Application by The North Lincolnshire Green Energy Park Limited for North Lincolnshire Green Energy Park
The Examining Authority's written questions and requests for information (ExQ1)
Issued on 23 November 2022

Responses are due by Deadline 2, Thursday 15 December 2022

INTRODUCTION_ES_SiteLocation_A01

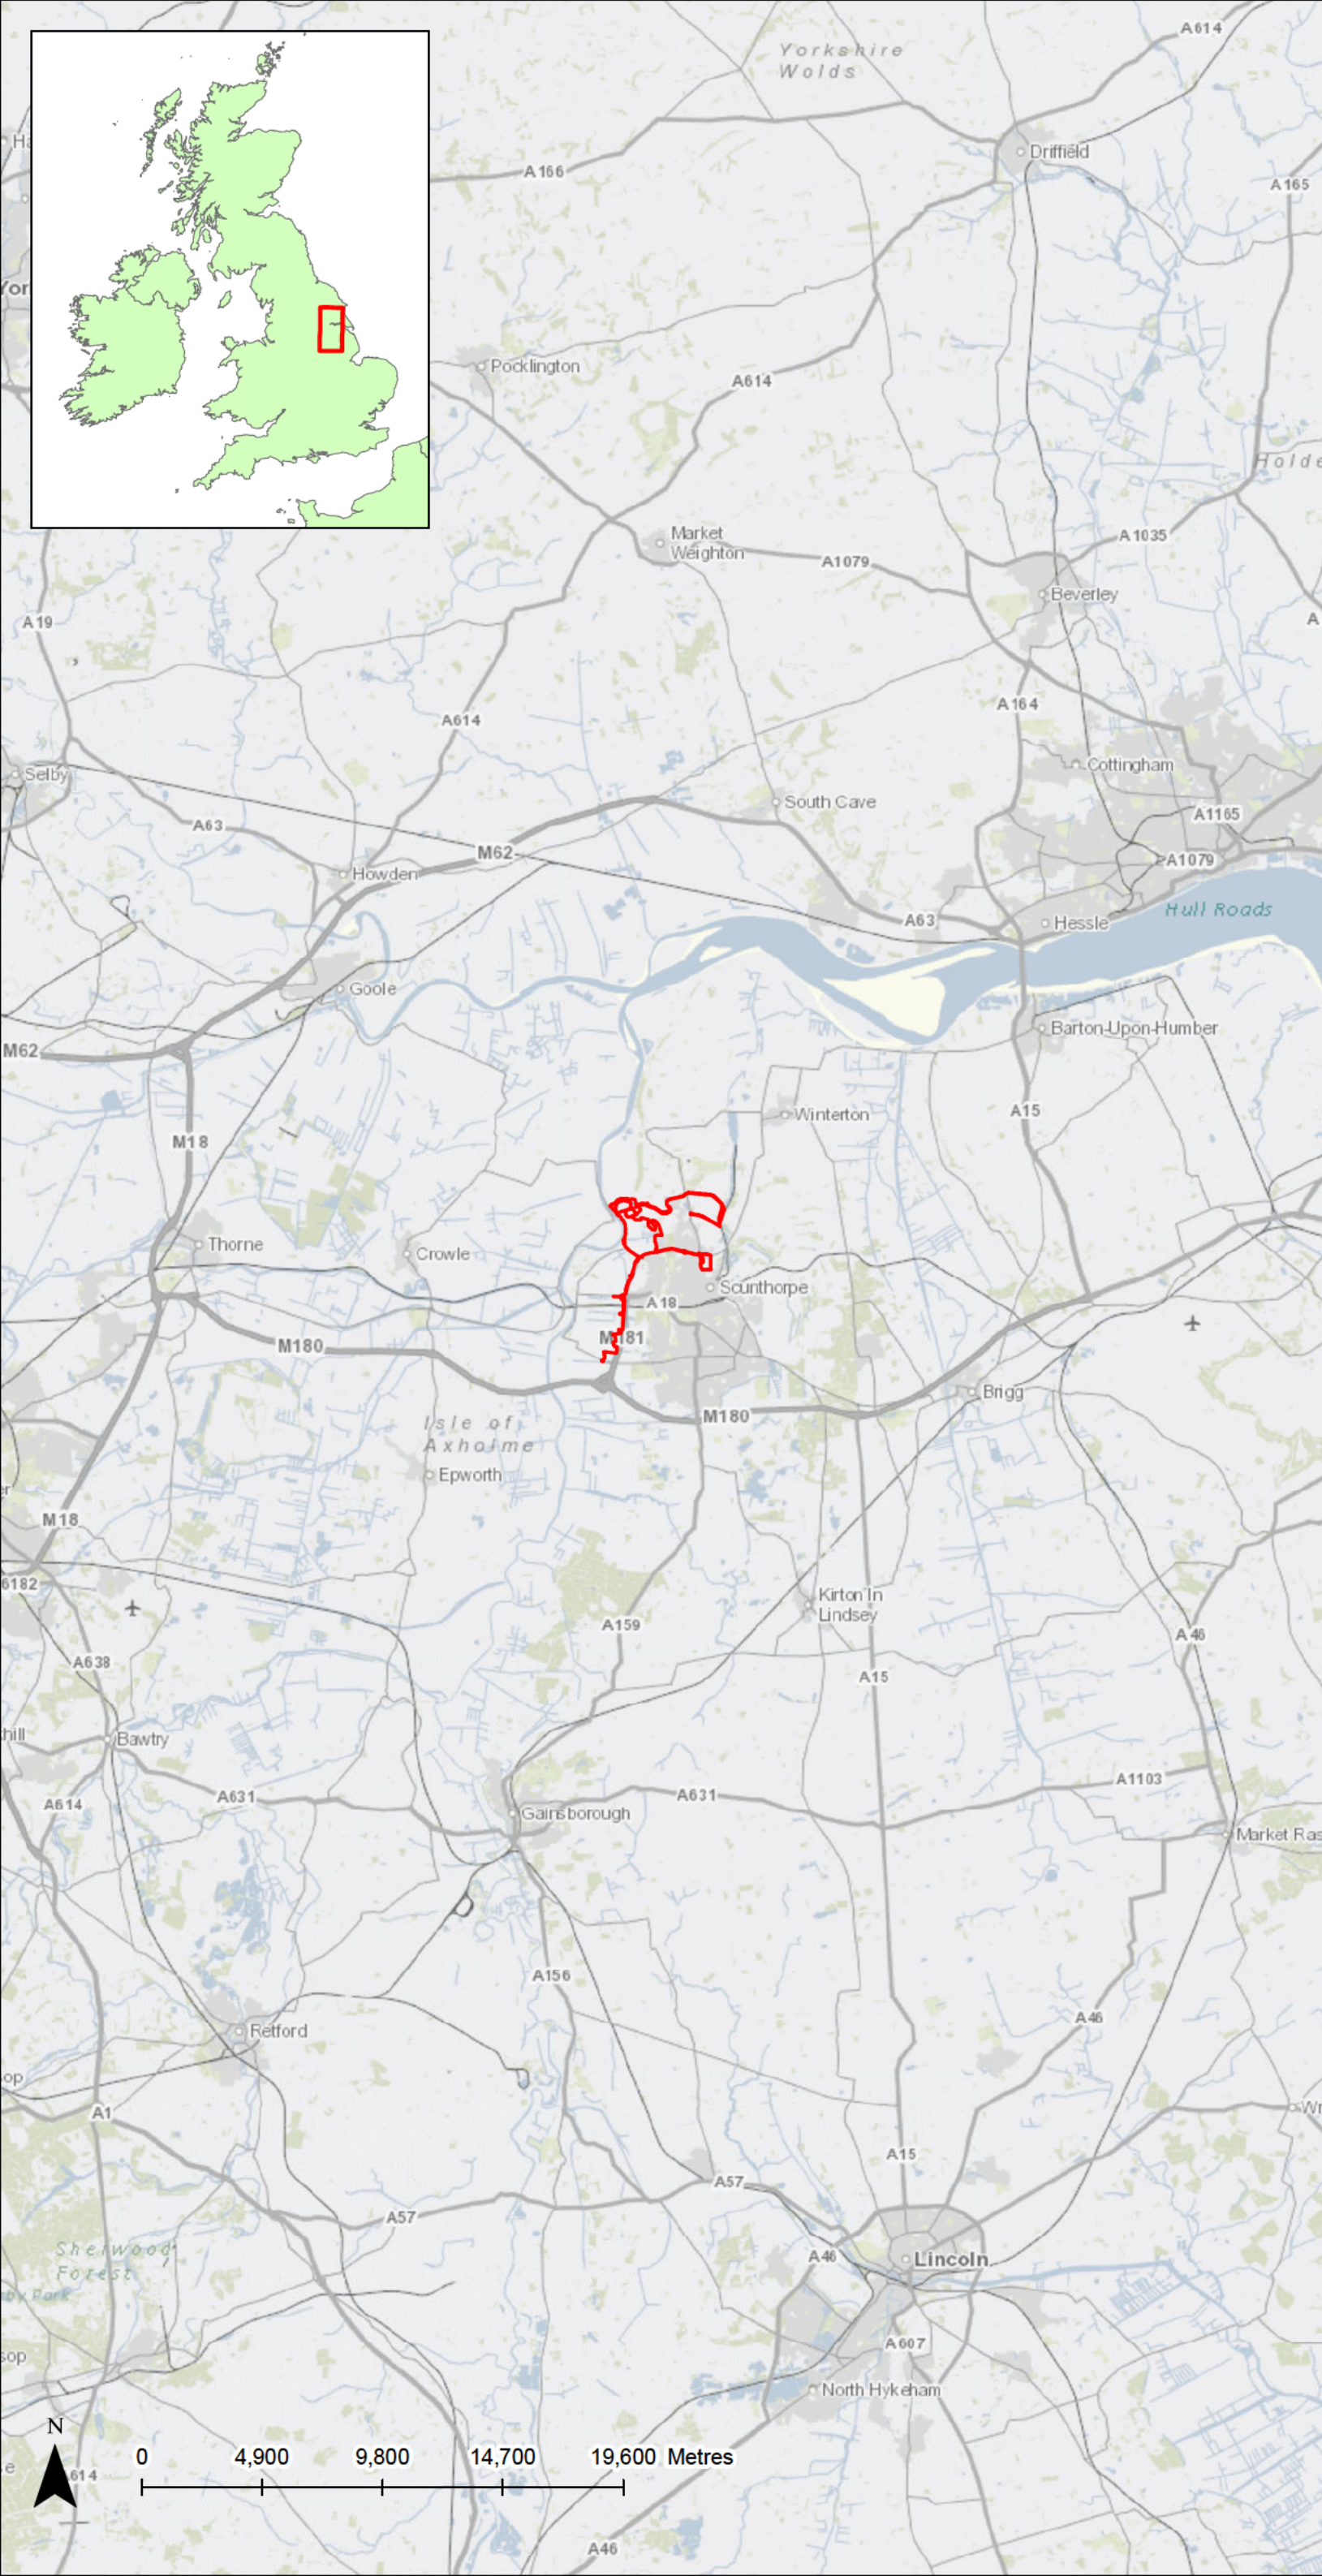
Q1.0.24	The Applicant	<p>Tree Planting and Ecological Enhancement</p> <p>Figure 3 of ES Chapter 1 Introduction [APP-049] identifies ‘Areas for Potential Future Mitigation’.</p> <p>(i) Can the Applicant confirm what is meant by this term, as the ExA understands from the Outline Landscape and Biodiversity Management and Monitoring Plan (LBMMP) [APP-041] and Indicative Landscape and biodiversity plan [APP-024] that these areas have been set aside for tree planting and an ecological enhancement area.</p>
Q1.0.25	The Applicant	<p>Exterior Storage Tanks</p> <p>In Chapter 3 [APP-051] at paragraph 3.2.2.25 it states “The facility will also be equipped with a fire water tank, sized to surpass the minimum requirements of NFPA 850”. 7 (National Fire Protection Agency)</p>
